**SYDNEY OLYMPIC PARK AUTHORITY
DESIGN REVIEW PANEL
ADVICE SHEET**

Project	3.1 – Site 68 – ecove Development
Presentation / Review Date	21 August 2014
Panel Present	Peter Poulet Bill Tsakalos Caroline Pidcock Prof Linda Corkery Prof Peter Webber Garry Fielding Darren Troy
COI Declaration	None
Also Present	David Martin - SOPA Ben Woods - SOPA
Presenters	Guy Lake - Bates Smart Mathieu Le Sueur - Bates Smart Mike Horne - Turf Design Studio Samantha Wilson - Urbis Bassam Aflak - ecove
Documents made available	Power Point Presentation and hard copy presentations
Inherited decisions	N/A
Previous relevant SOPA Advice	Nil
General Observations/ Overall Comment	<p>Guy Lake provided an outline of the proposal to date, identifying that changes to the design had occurred in response to the Jury's comments. He noted that some of the points are still a work in progress.</p> <p>The DRP noted the ongoing development of the design and advised the proponent should be commended for responding so positively to the recommendations of the Jury.</p>

Garden Pockets

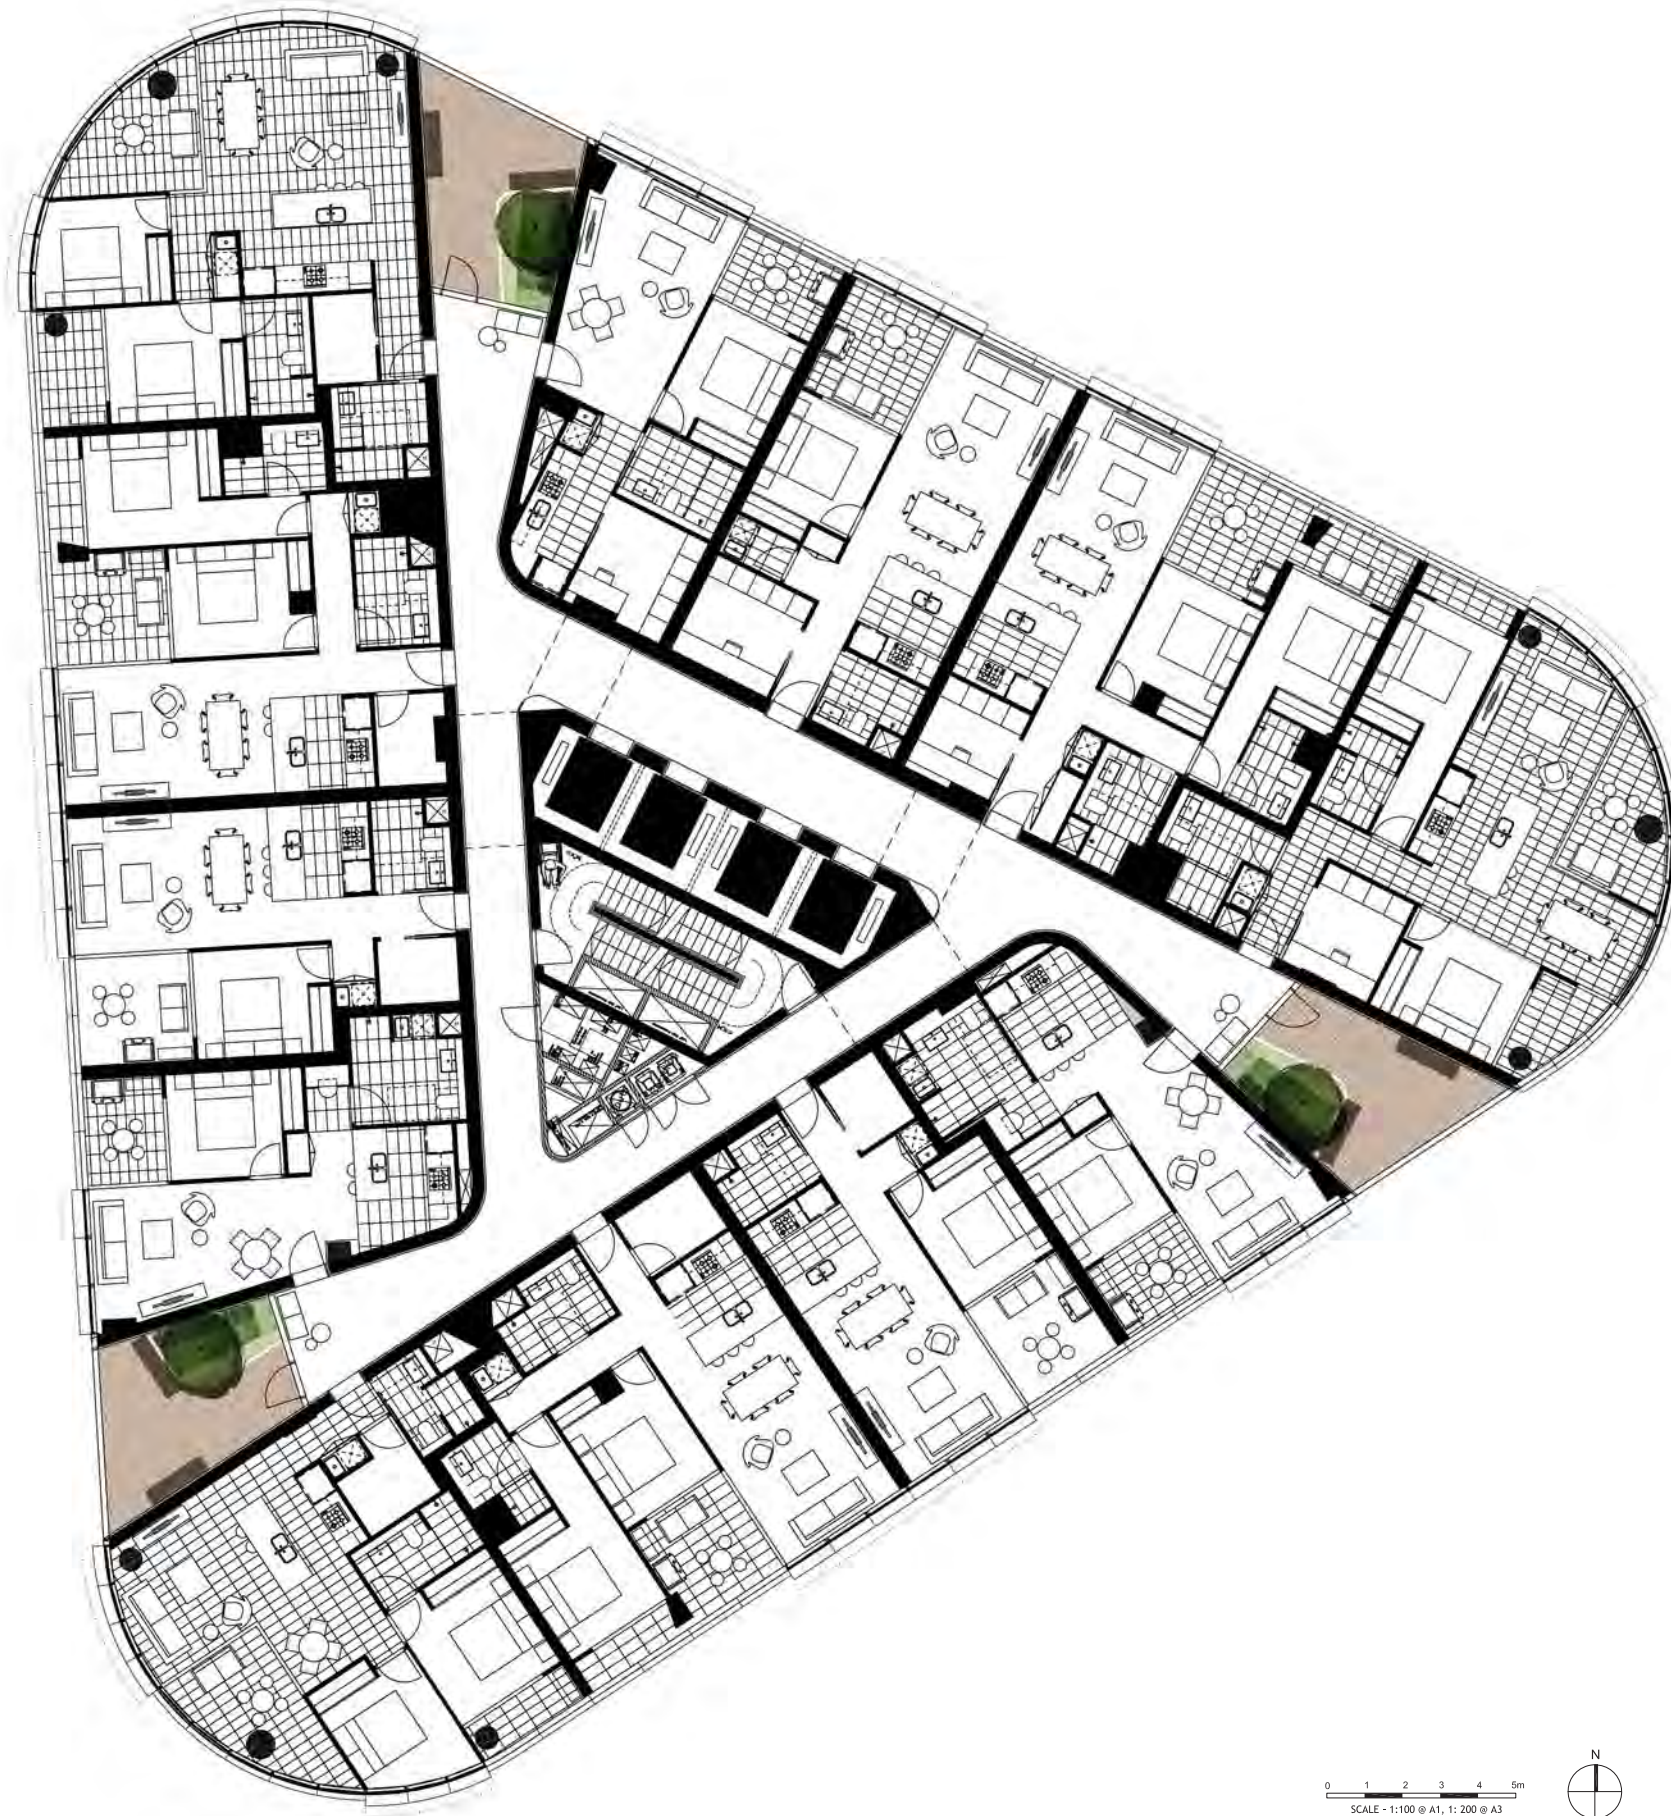
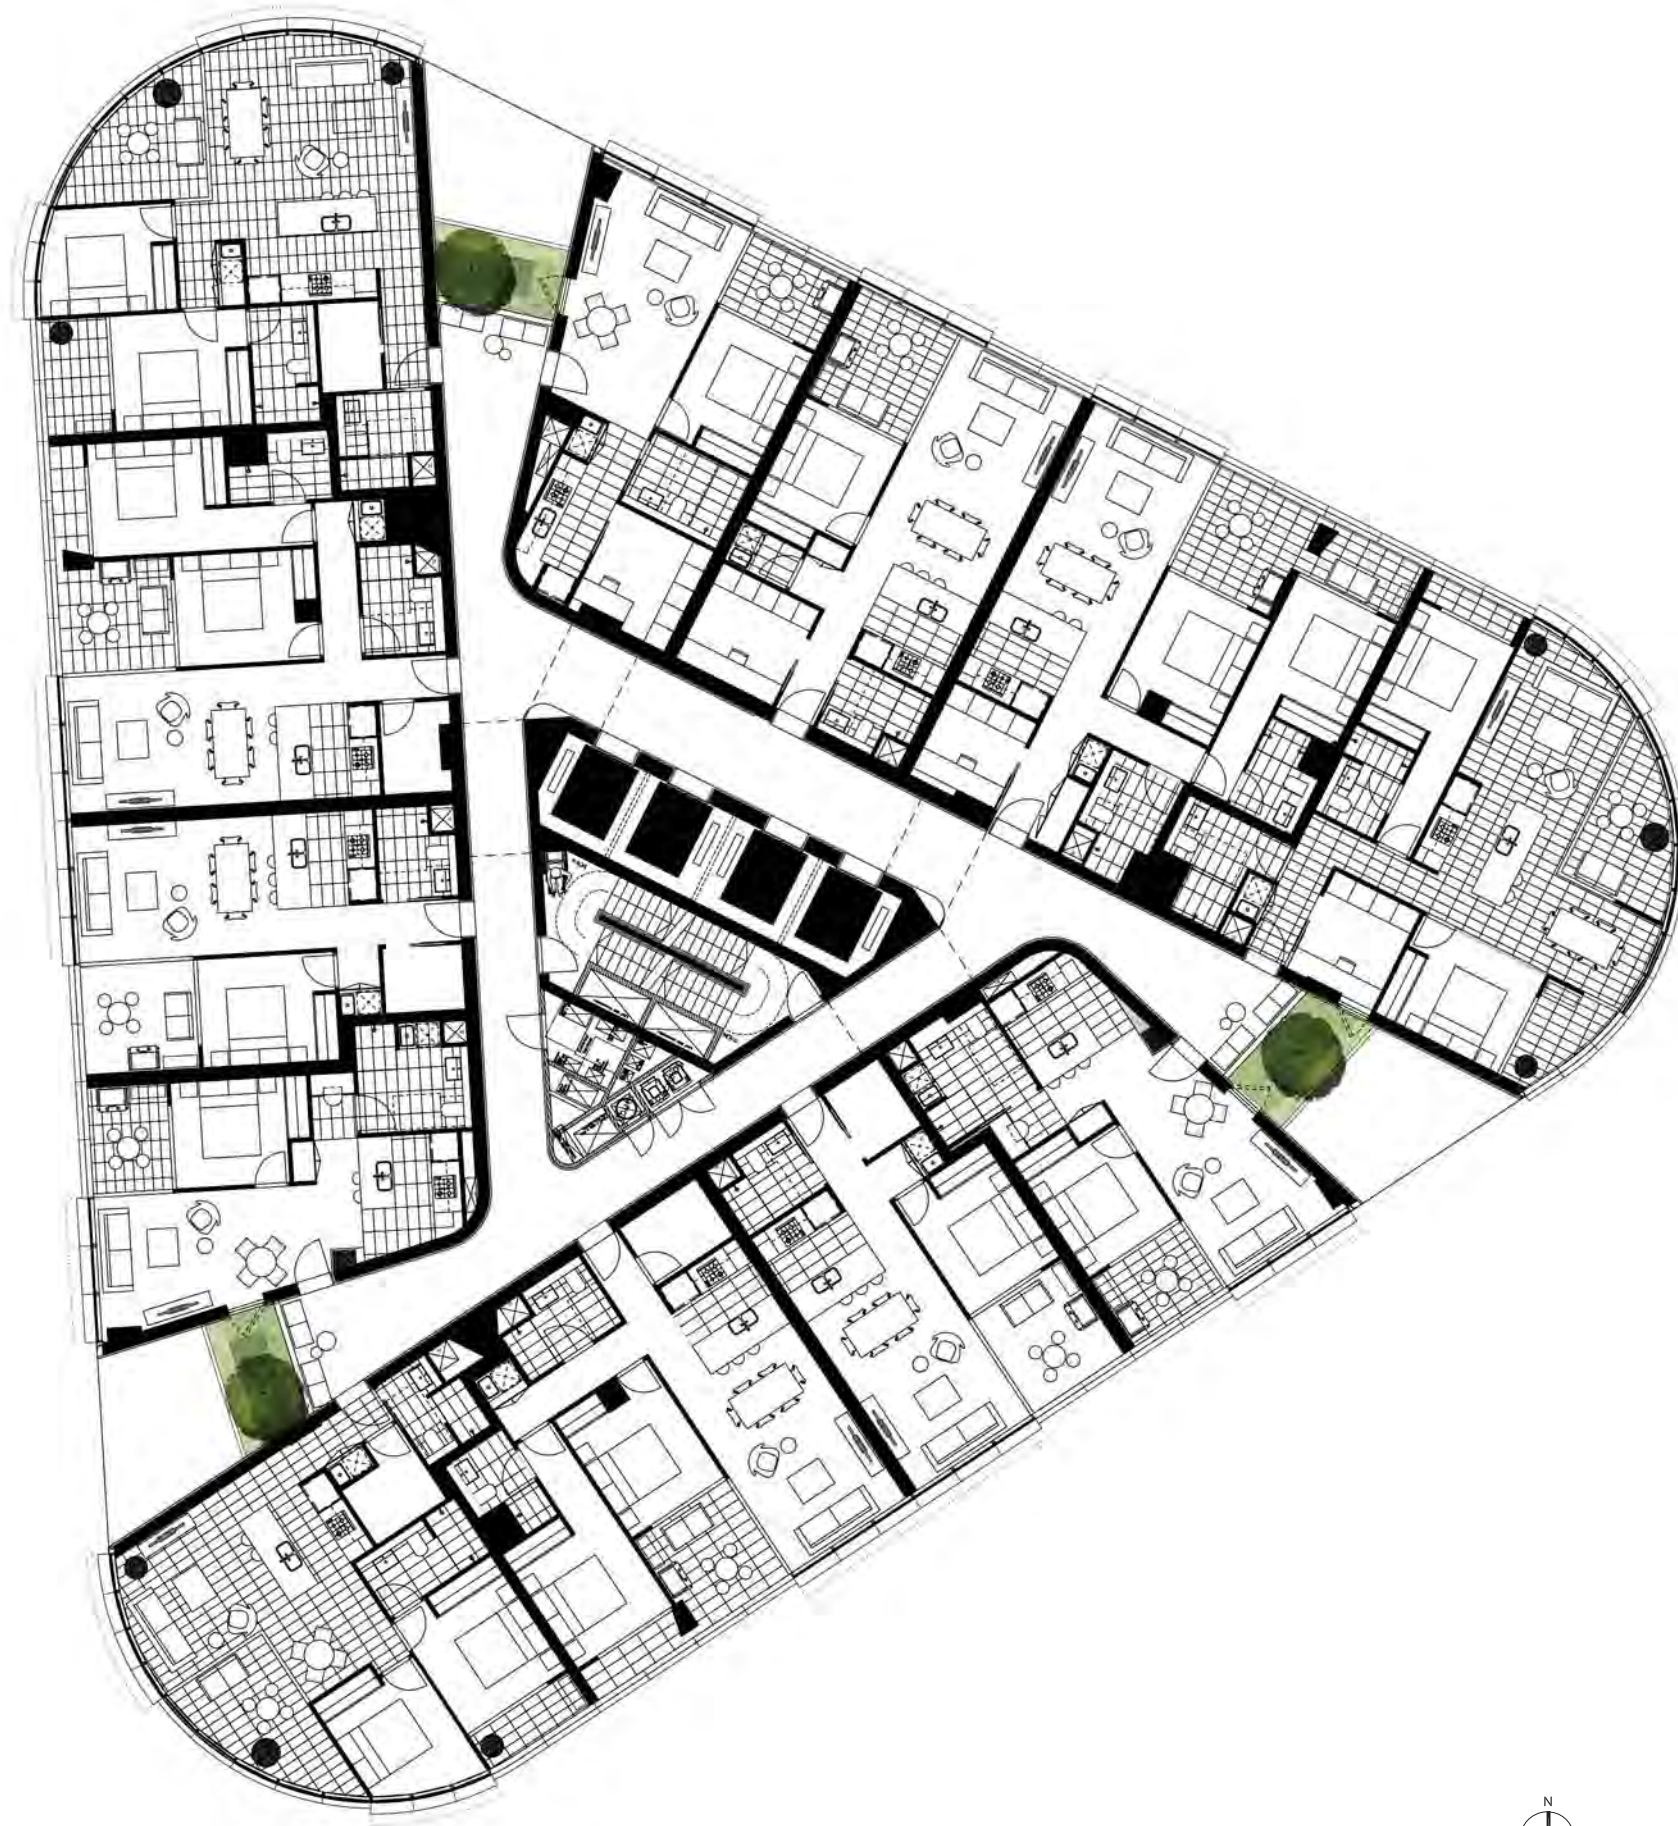
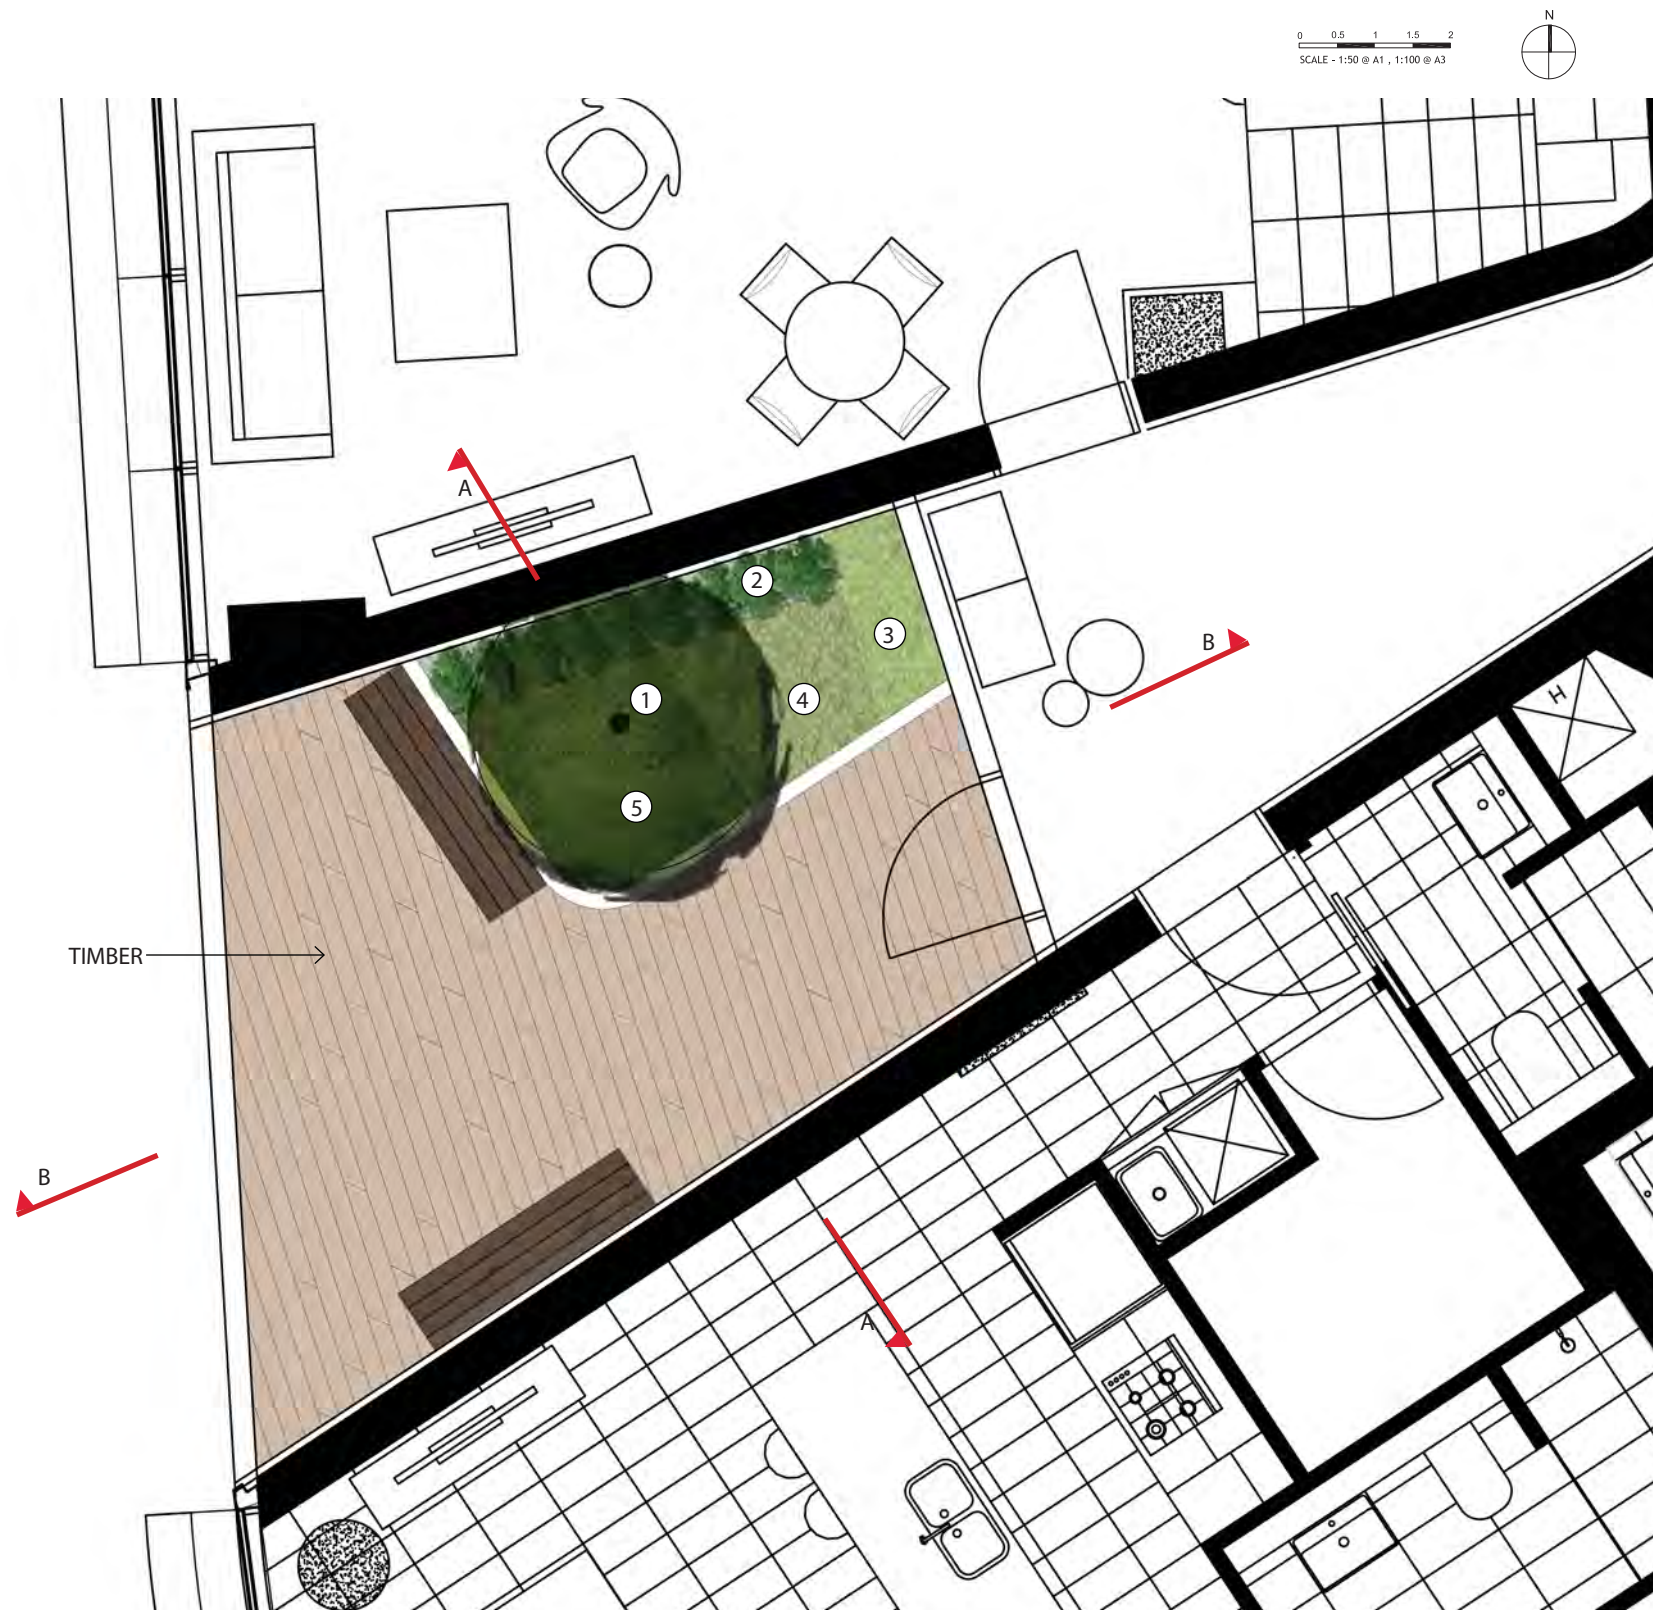
Issues	<p>The DRP had the following concerns:</p> <ul style="list-style-type: none"> The Panel felt that garden walls to each slot may not necessarily be achievable/sustainable, with perhaps the use of large planting (statement tree) on the base of the slot being

<p>worthy of consideration. Consideration to other means of adding warmth to these areas should also be explored.</p> <ul style="list-style-type: none"> The Panel did not feel it was their place to resolve the colour pallet for the façade. It was however noted that the addition of the aluminium was not ideal and provided a loss of materiality. Similarly the elementary approach to the use of colour did not seem appropriate. The Panel suggested the façade should be subtle as residential buildings should not be iconic in this precinct, but an element of playfulness should also be provided to ensure it does not have a 'commercial' appearance. It was noted that there are a number of highly exposed balconies, particularly on corners in relation to wind, and privacy is an issue for lower level balconies. Appropriate treatment should be provided in response. Garbage management within the building needs to be well thought out and resolved for ease of use by residents. Similarly, loading facilities for removalist vehicles, furniture deliveries etc. need to be provided with easy access to the building and lift. Consideration to travel paths within the building should occur.

Recommended Supporting Action	<p>The DRP recommends that:</p> <ul style="list-style-type: none"> Further refinement/treatment of the slots should be undertaken. Continued resolution of the façade and other issues raised above.
Circulation of Advice	SOPA, proponents
